STATUTORY PLANNING CONSULTATION RESPONSE

Application Number:	3/2026/0314
Proposal:	Approval of details reserved by condition 18 (Travel plan), condition 19 (Construction Management Plan), condition 23 (Surface Water Drainage Scheme) and condition 25 (Construction Environmental Management Plan) on planning permission 3/2020/0601.
Location:	Land at Highmoor Farm Clitheroe BB7 1PN

Lead Local Flood Authority Position

Client: MORRIS HOMES  
 Project: HIGHMOOR FARM, CLITHEROE  
 Title: Drainage Strategy Layout - Masterplan

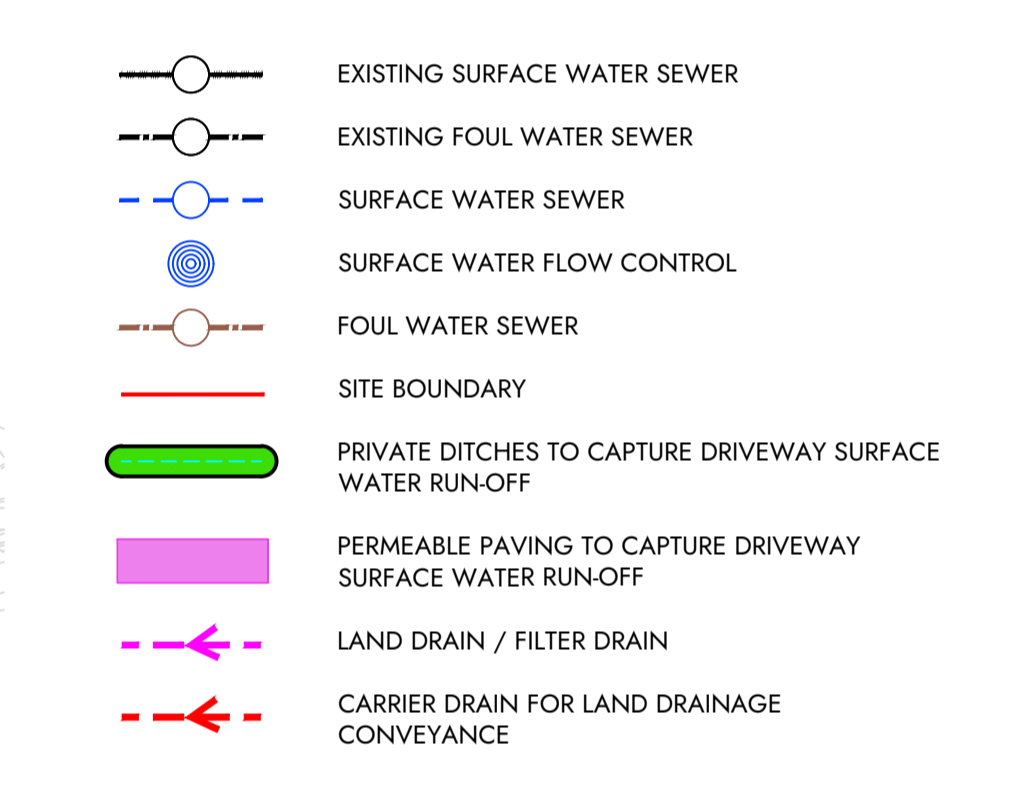
- The applicant has provided evidence within the catchment plan of a contributing area of approximately 2.444ha, however the applicant has provided evidence of the greenfield scenario being based on 3.973ha, giving a Qbar of approximately 37.5l/s, although this approach was acceptable in principle, the contributing areas used to calculate the existing scenario and the proposed development are

expected to be consistent. Should the applicant only intend to drain the impermeable areas (including the area for the proposed basin) then the proposed final discharge rate should also be based on the same contributing area.
